**Re: Planning application for erection of 45 dwellings East of 28 Northorpe Lane, Mirfield, WF14 0QN
& removal of land from Northorpe Hall
Application Number: 2021/62/91914/E**

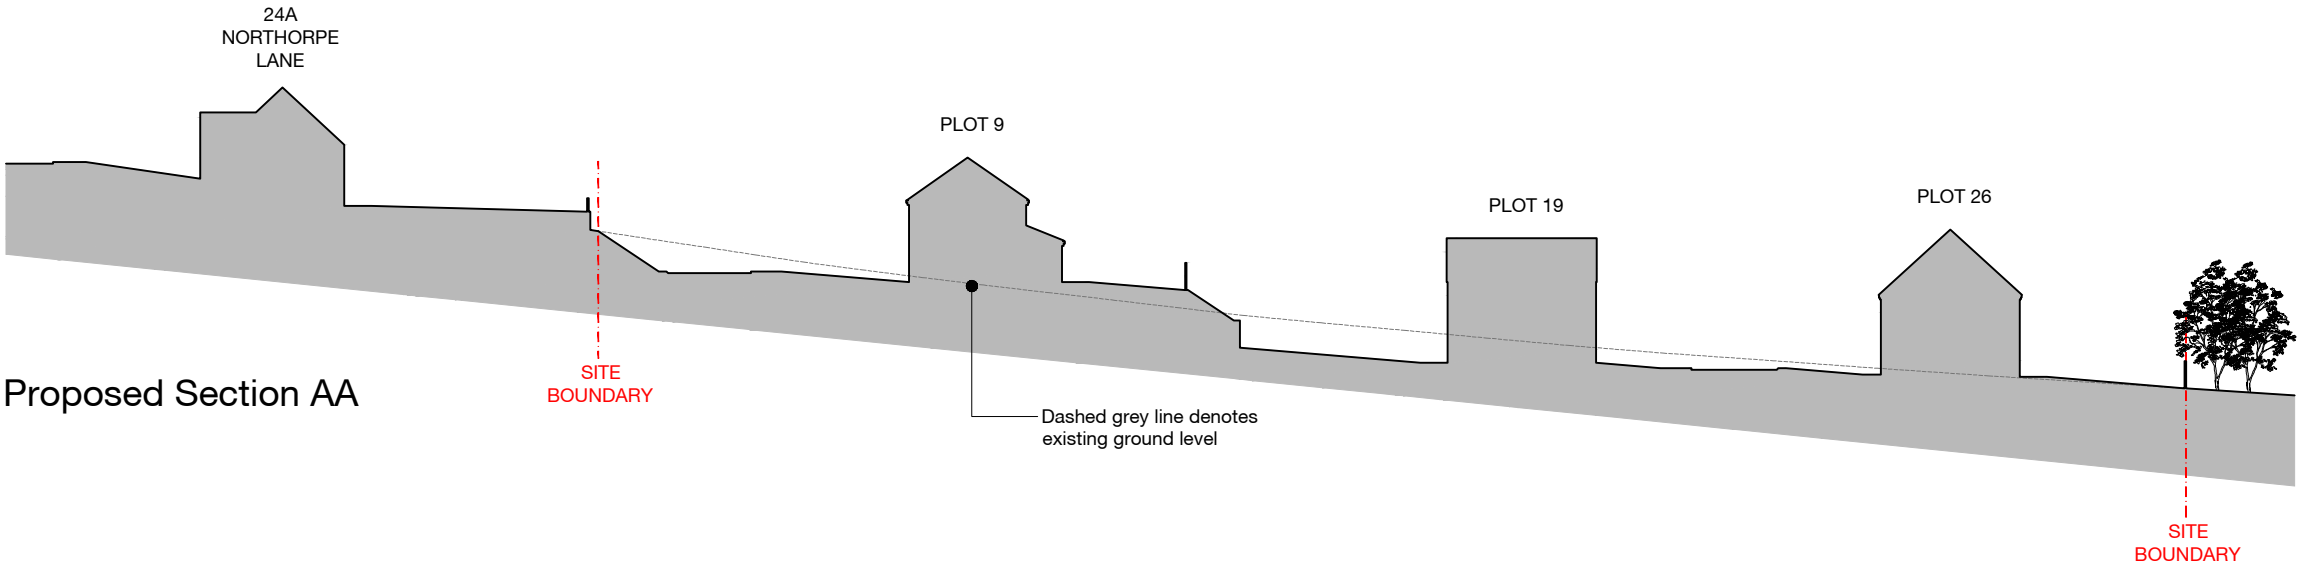
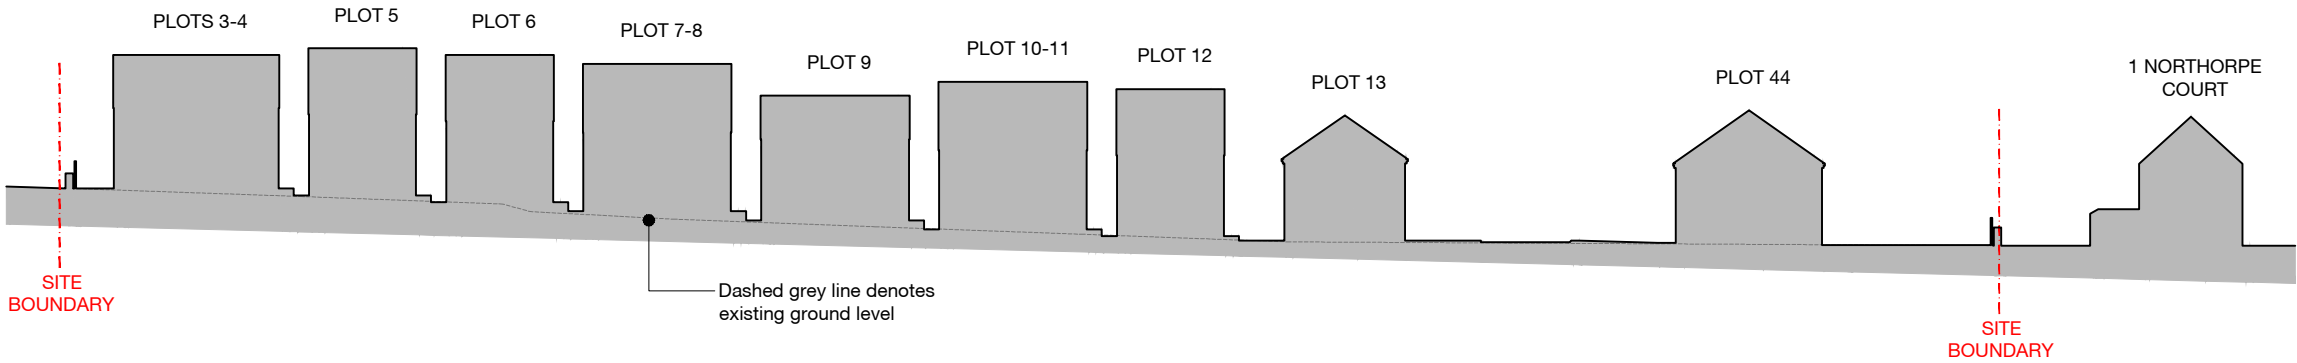
The site will require 'cut and fill' groundworks to accommodate the new houses due to its sloping nature. In fact a massive 17,000 cubic metres of fill material will have to be brought onto the site in addition to whatever is 'cut' at the upper levels! This will undoubtedly disturb the water table and local network of springs. The displacement of ground water, particularly during periods of heavy rainfall will contribute the existing flooding issues on North Road, which lies down-hill from the site. Even if the occupiers of the new homes are not directly affected, the knock-on effect to other householders and the wider community will be unacceptable. Who will be responsible for the problems? I imagine Kirklees Council will be reluctant to take any responsibility.
